Rezoning Transportation Analysis

Petition Number: 2020-156

General Location Identifier: Tax ID: 14125114

Date	Description
11-30-2020	First Review (KP)
01-21-2021	Second Review (KP)
02-25-2021	Third Review (KP)

ENGINEER: GTW
 DRAWN BY: EBT
 CHECKED BY: LB
 PROJECT #: 020.031
 SHEET: **RZ-1**
 (SHEET 1 OF 2)

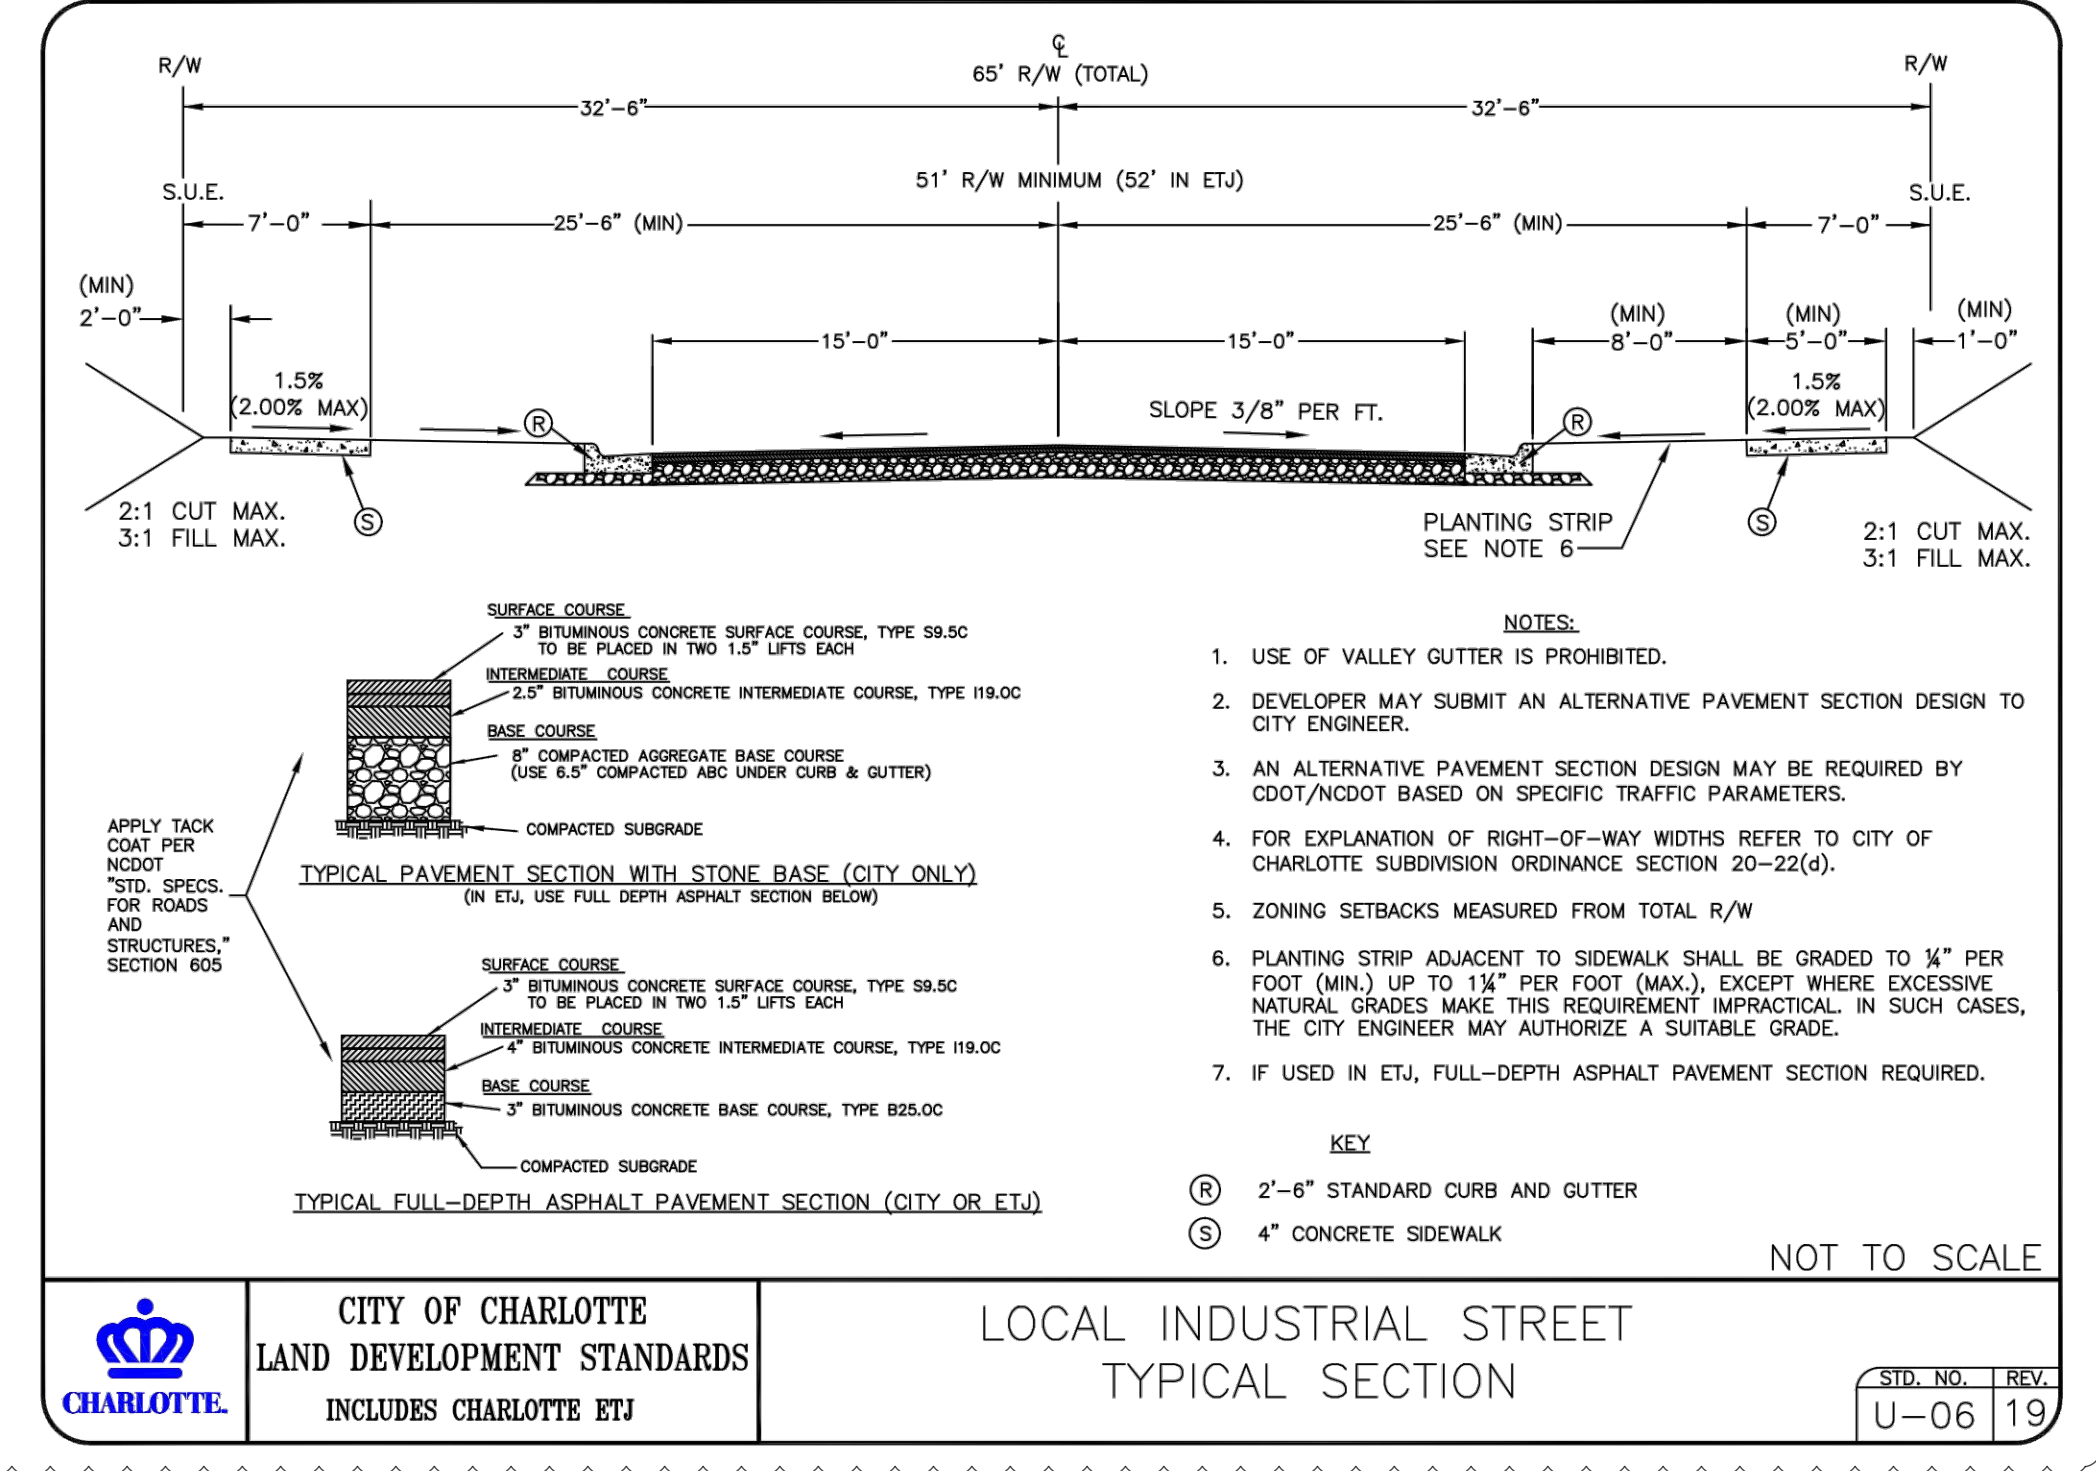
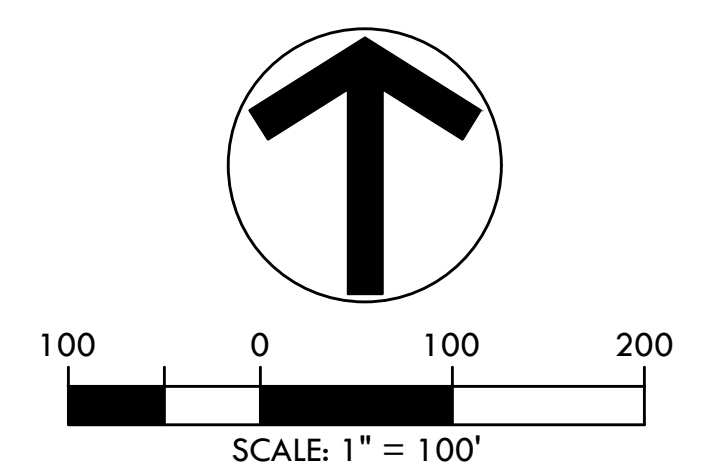
10. **New comment as a result of the 01-12-2021 resubmittal:** Revise the site plan and add a conditional note to coordinate with NCDOT, during permitting, to revise the median and/or turn lane striping, along the site's Shopton Road frontage, in accordance with NCDOT Standards.

11. **New comment as a result of the 01-12-2021 resubmittal:** Revise the site plan by including a detail showing the roadway transition from the new public Local Industrial Street Cross Section, U-06, to the existing cross section of the privately owned Pinecrest Drive. Please include dimensions in this detail.

12. **New comment as a result of the 01-12-2021 resubmittal:** Revise the site plan and conditional note 3.F to "Petitioner shall dedicate 85-foot of right-of-way, as generally depicted on the site plan, for the future Shopton Road Extension-CTP Alignment."
